CITY OF ALBUQUERQUE

March 25, 2019

Re: Cedar Apartments
541, 543, 545 Cedar SW. Albuquerque, NM 87106
Traffic Circulation Layout
Engineer's/Architect's Stamp 07-11-18 (K15-D062)

CEDAR APARTMENTS
OVERALL SITE PLAN - LOWER / GROUND LEVEL
541,543,545 CEDAR SE, ALBUQUERQUE NM 87106
PROJECT #1761

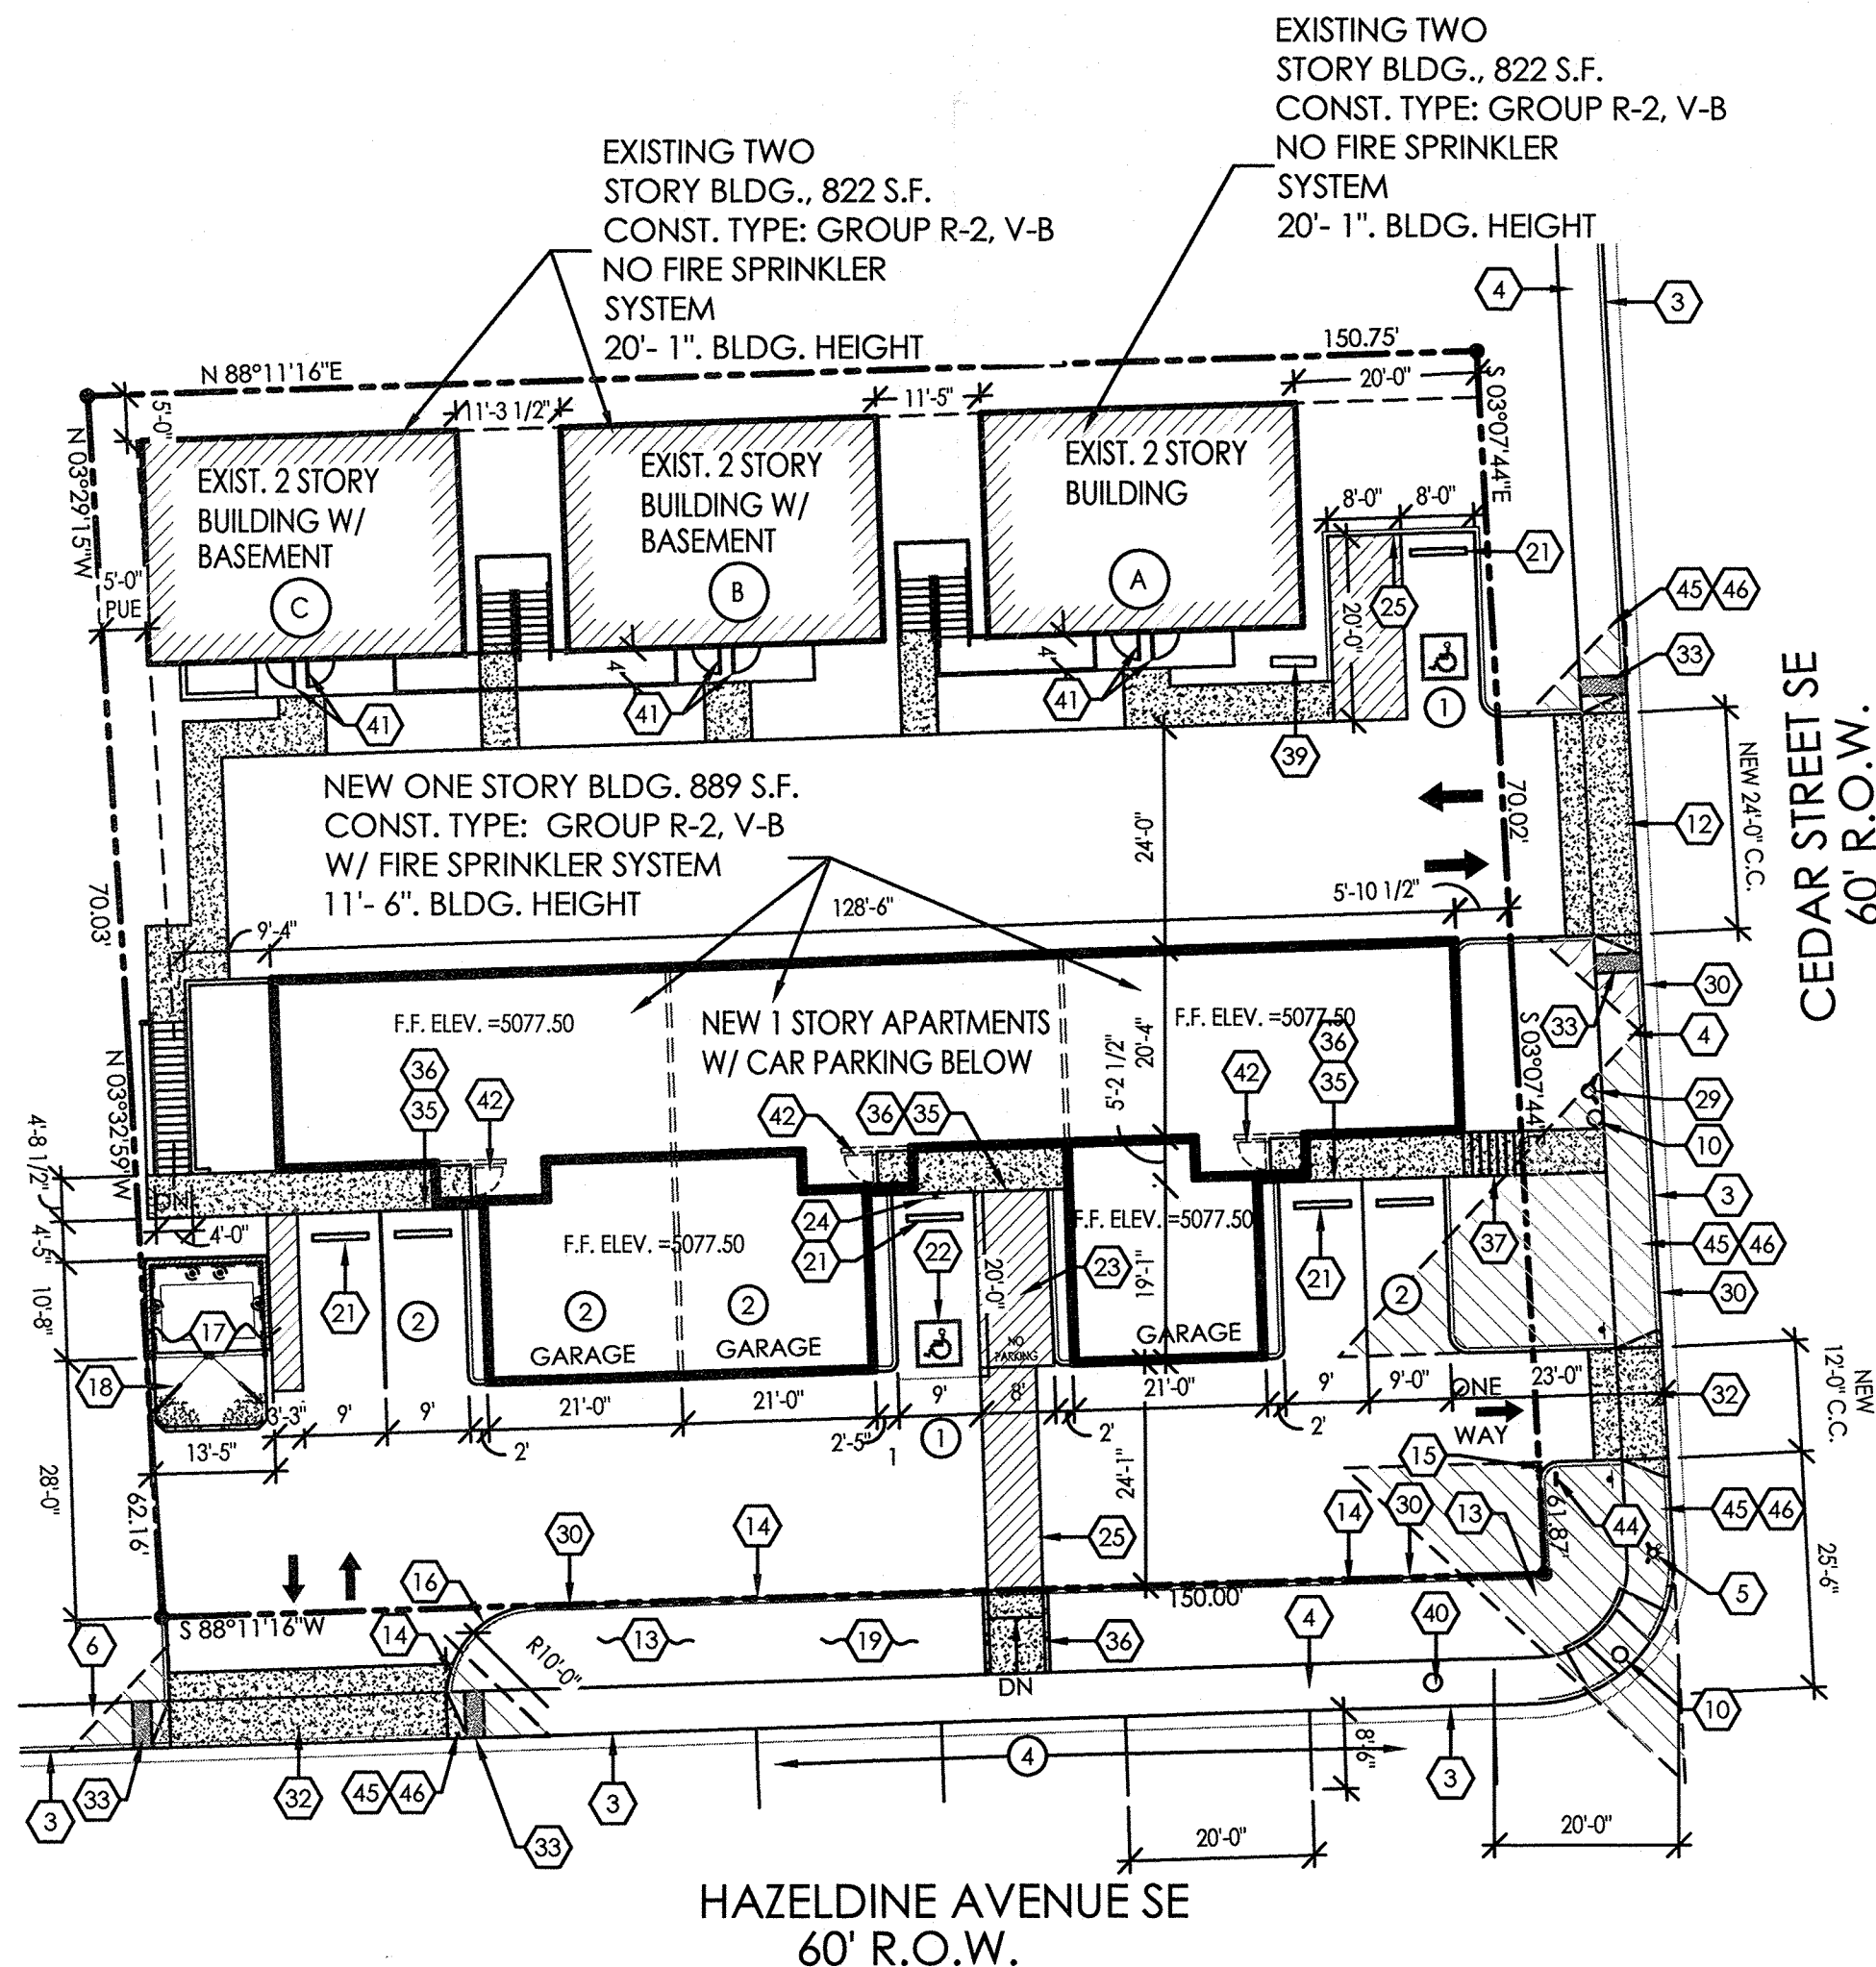
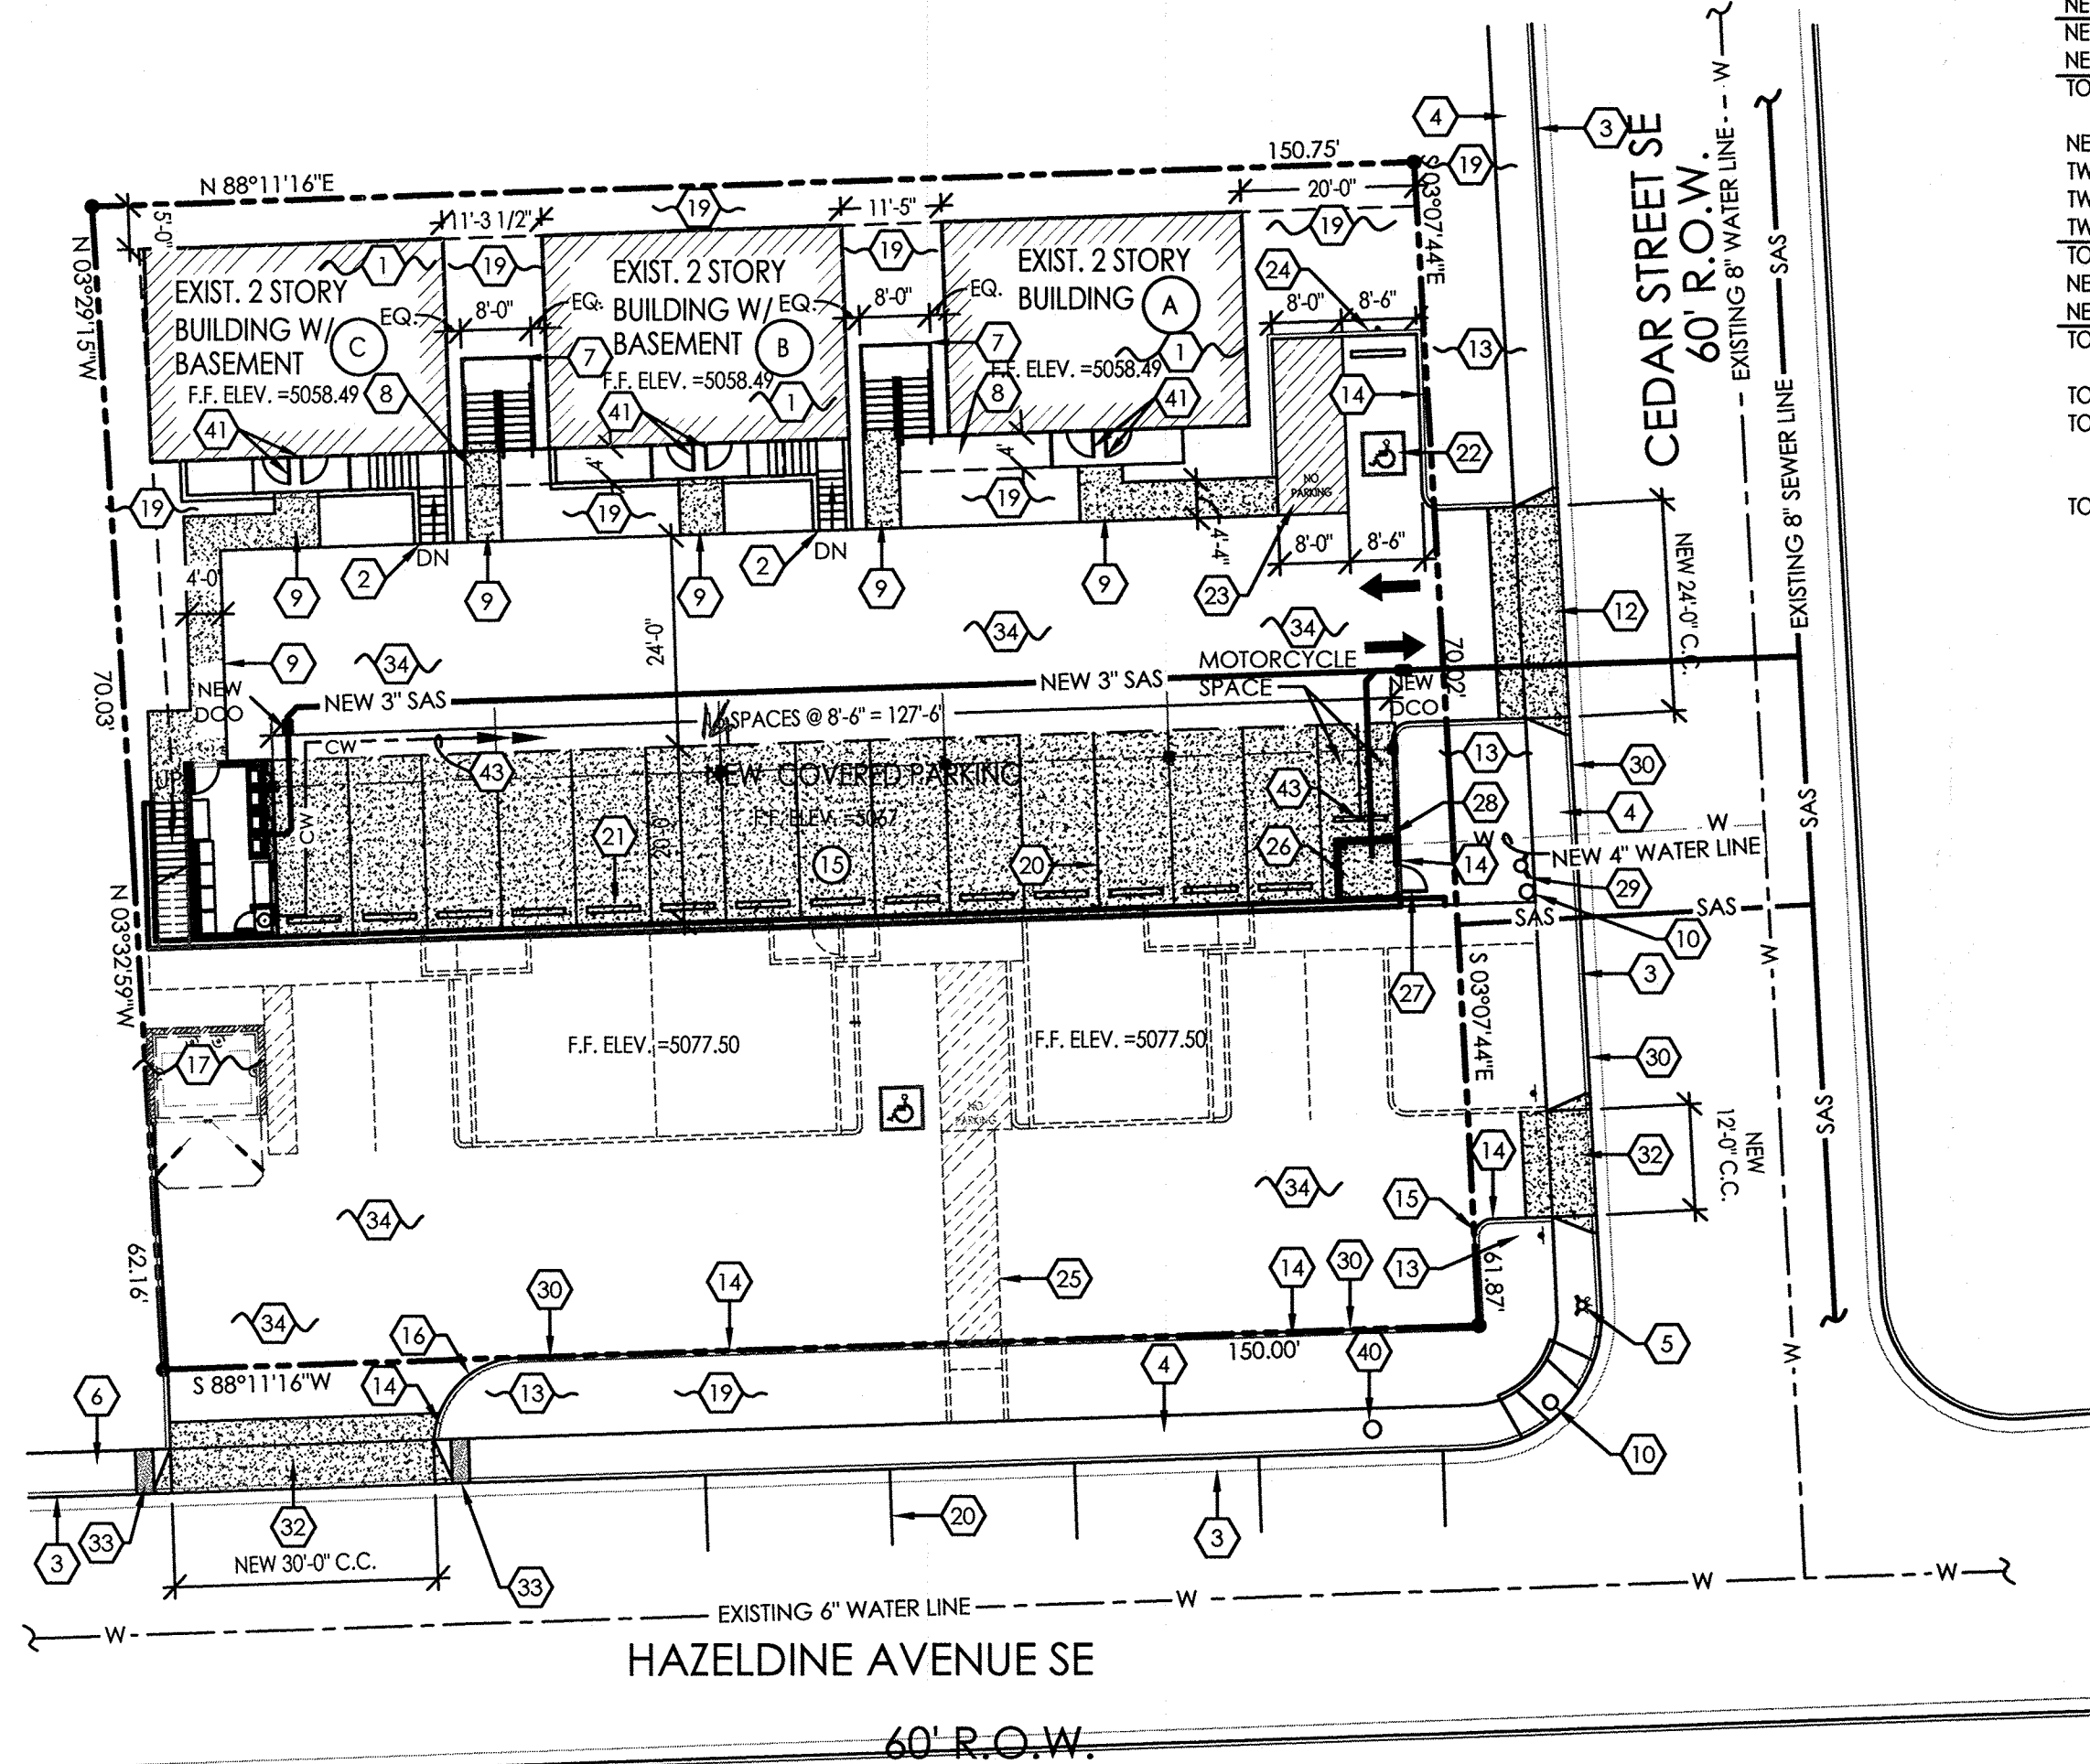
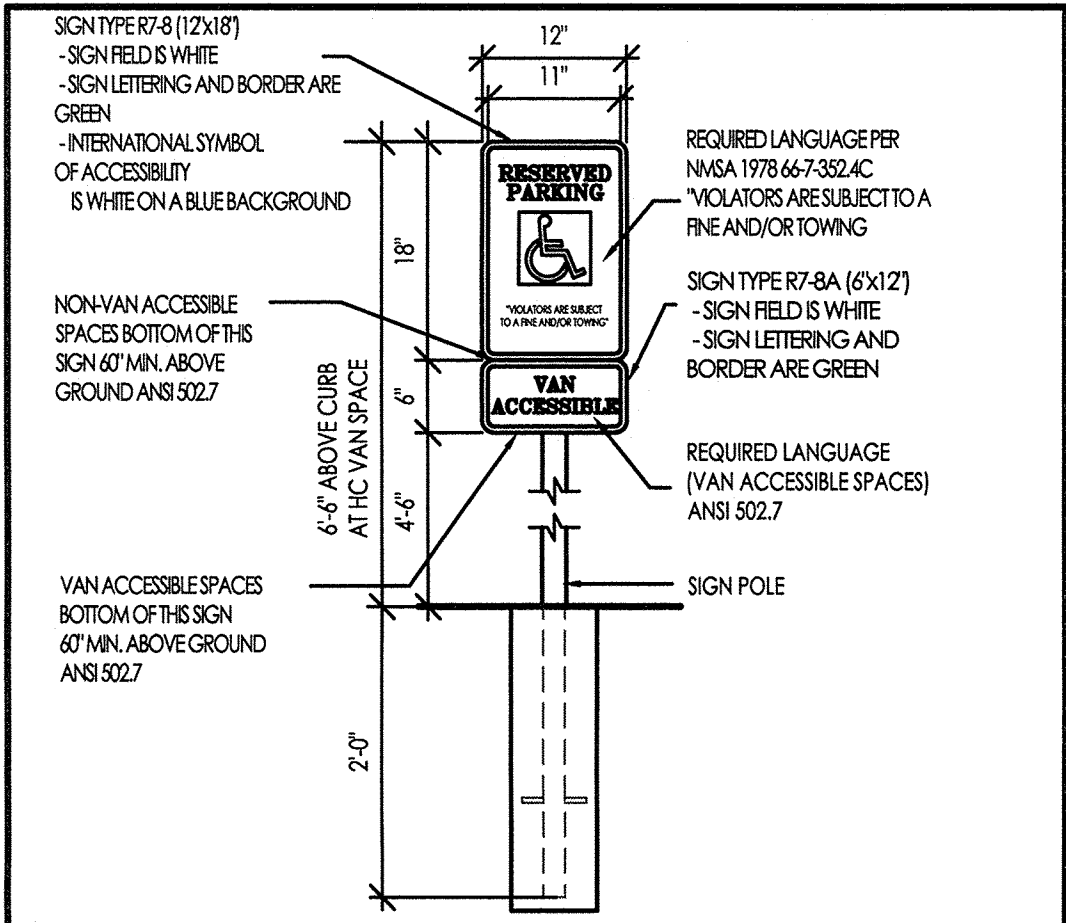
1. Please provide grading for parking and include the elevations of the building.
2. The ADA accessible parking sign must have the required language per 66-7-352.4C NMSA 1978 **"Violators Are Subject to a Fine and/or Towing."** Please call out detail and location of HC signs. Please include a detailed sheet. **There is no AS-2.0 attached.**
3. Motorcycle parking spaces shall be designated by its own conspicuously posted upright sign, either free-standing or wall mounted per the zoning code.
4. Please remove all the clouds on your next submittal.
